CITY OF ALBUQUERQUE

PLANNING DEPARTMENT – Development Review Services

June 9, 2014

RE: **Valle Vista at the Trails**
Drainage Report for Valle Vista at the Trails Subdivision
Engineer's Stamp Date 5-16-2014 (File: C09D009)

VALLE VISTA UNITS 1, 2 & 3
GRADING AND DRAINAGE PLAN

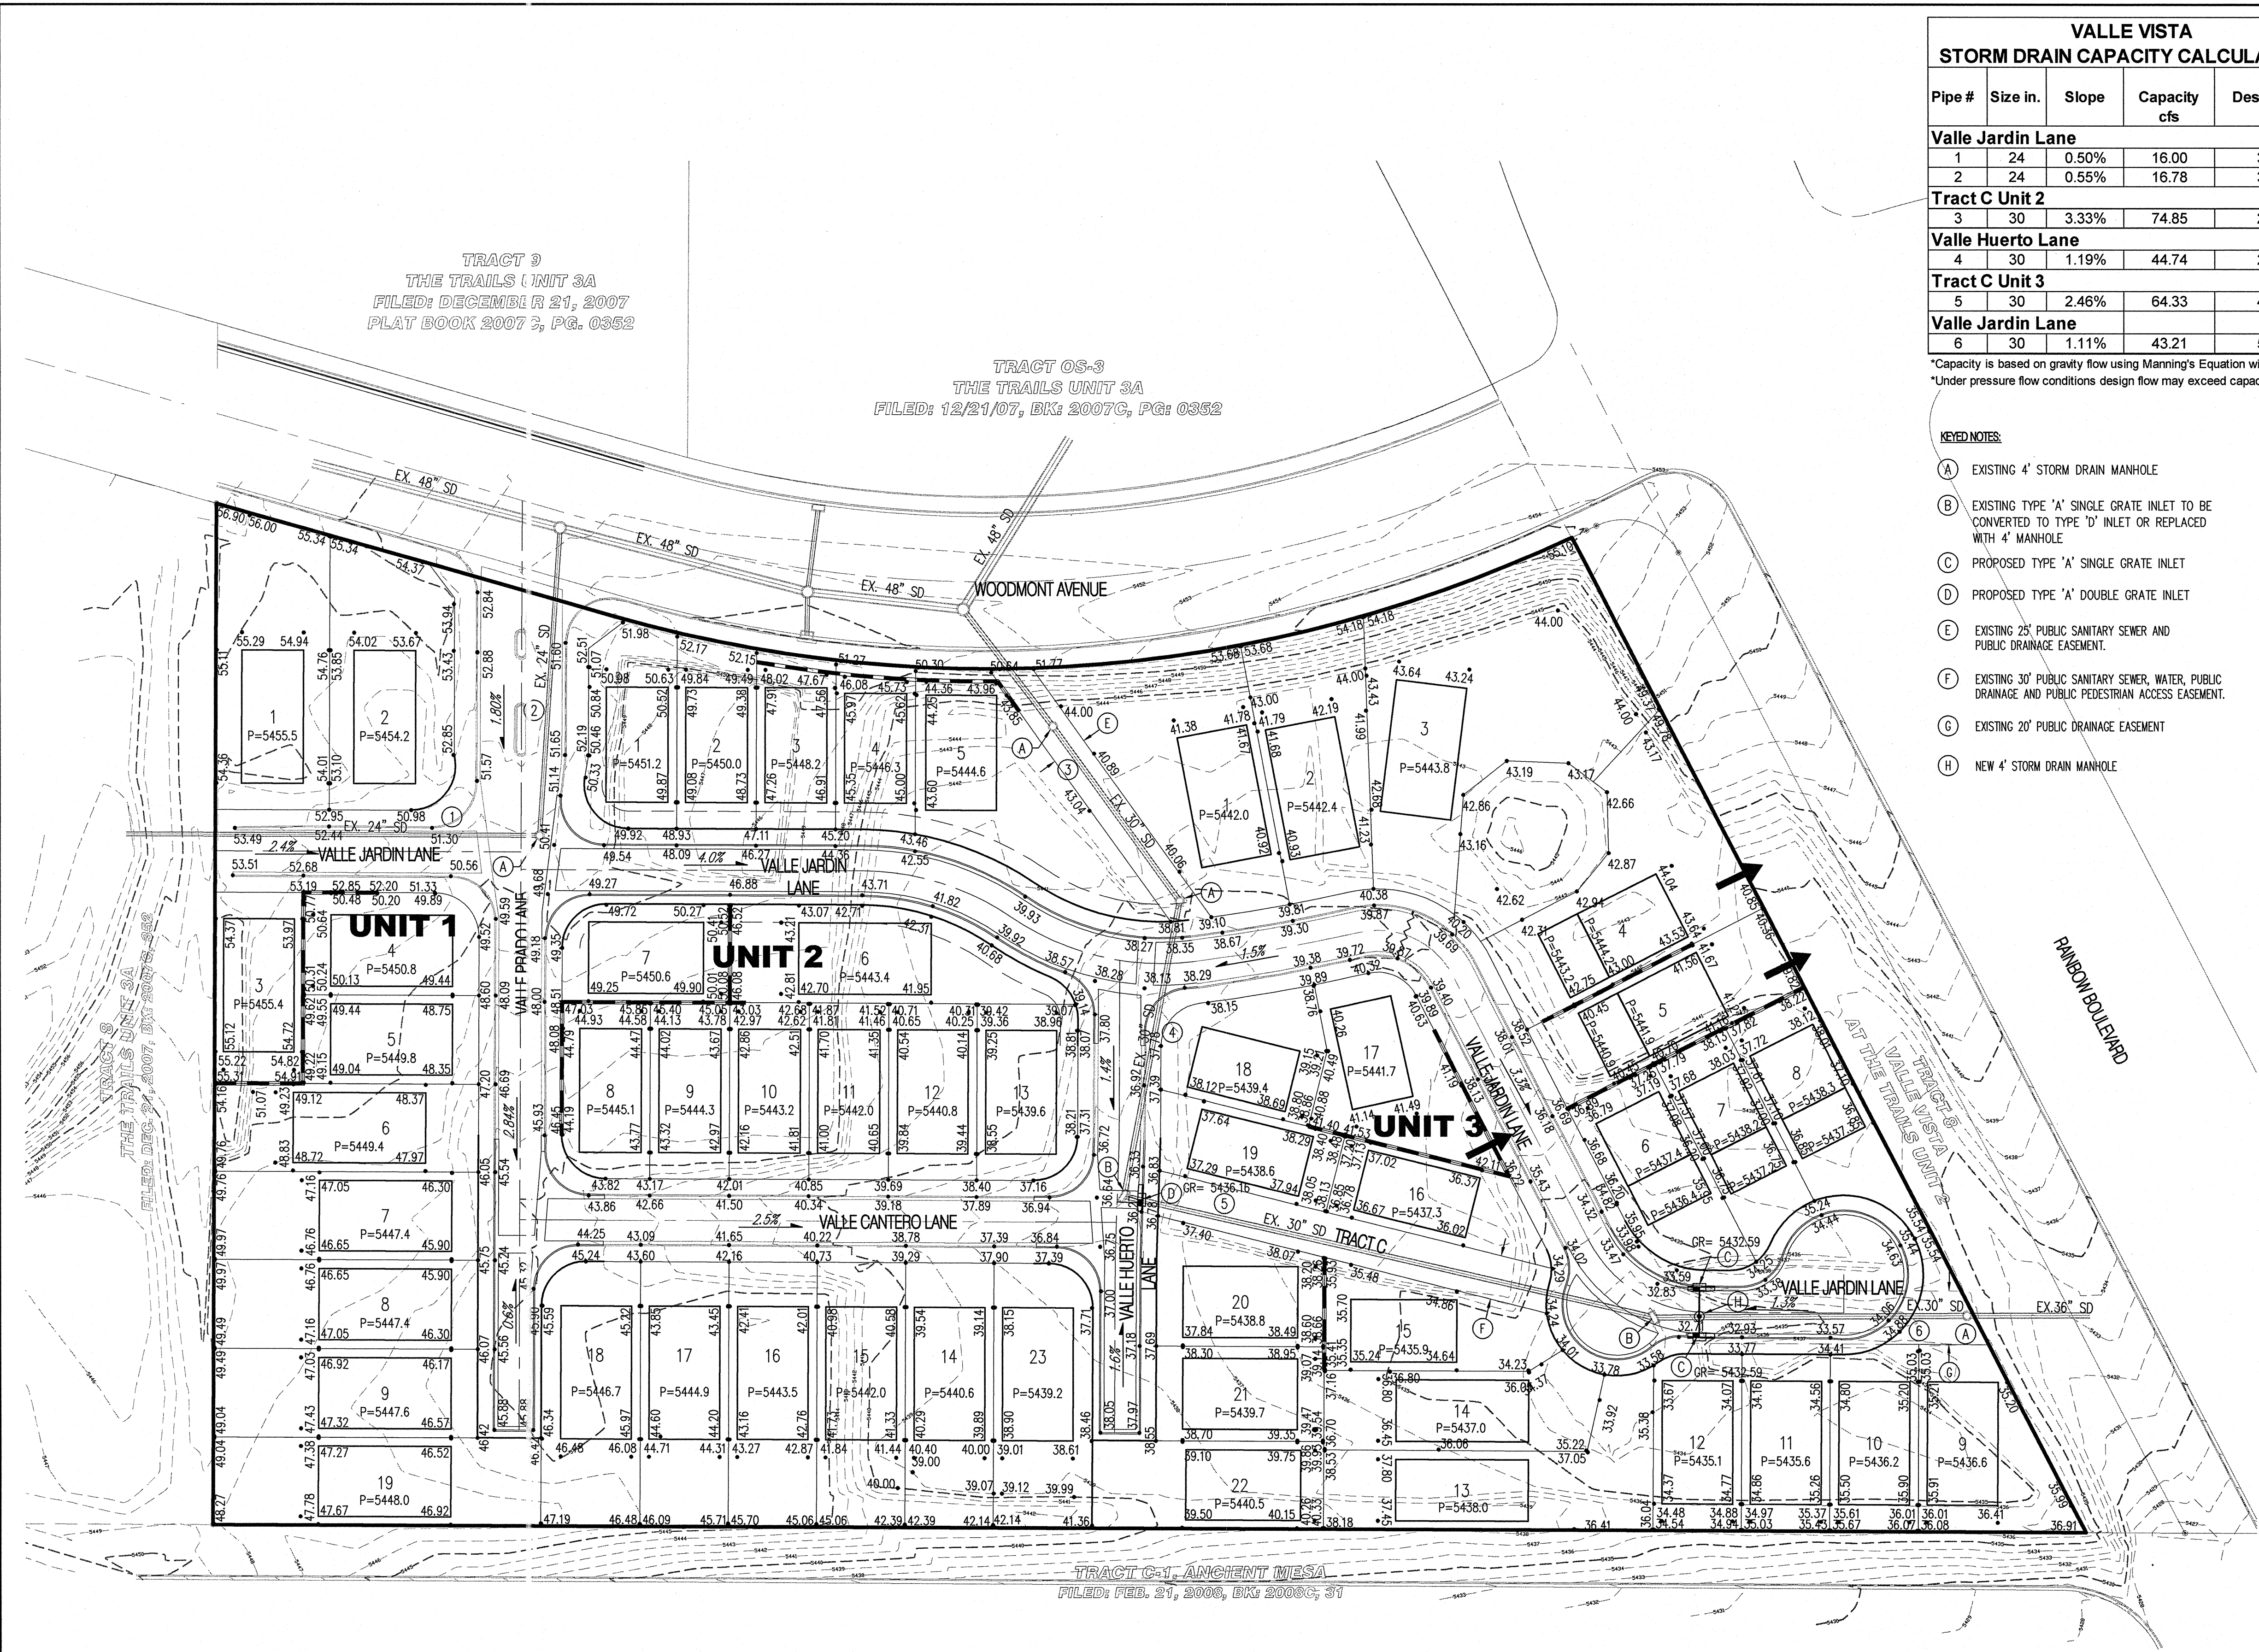
9. Show existing contours on the south side of the subdivision.
10. Show sizes of all existing storm drain and manholes, and any new manholes. Show pipe flows.
11. Show inlet locations, sizes, and T.O. Grate elevations.
12. Are there new Manholes where new/relocated inlets tie into existing stormdrains?
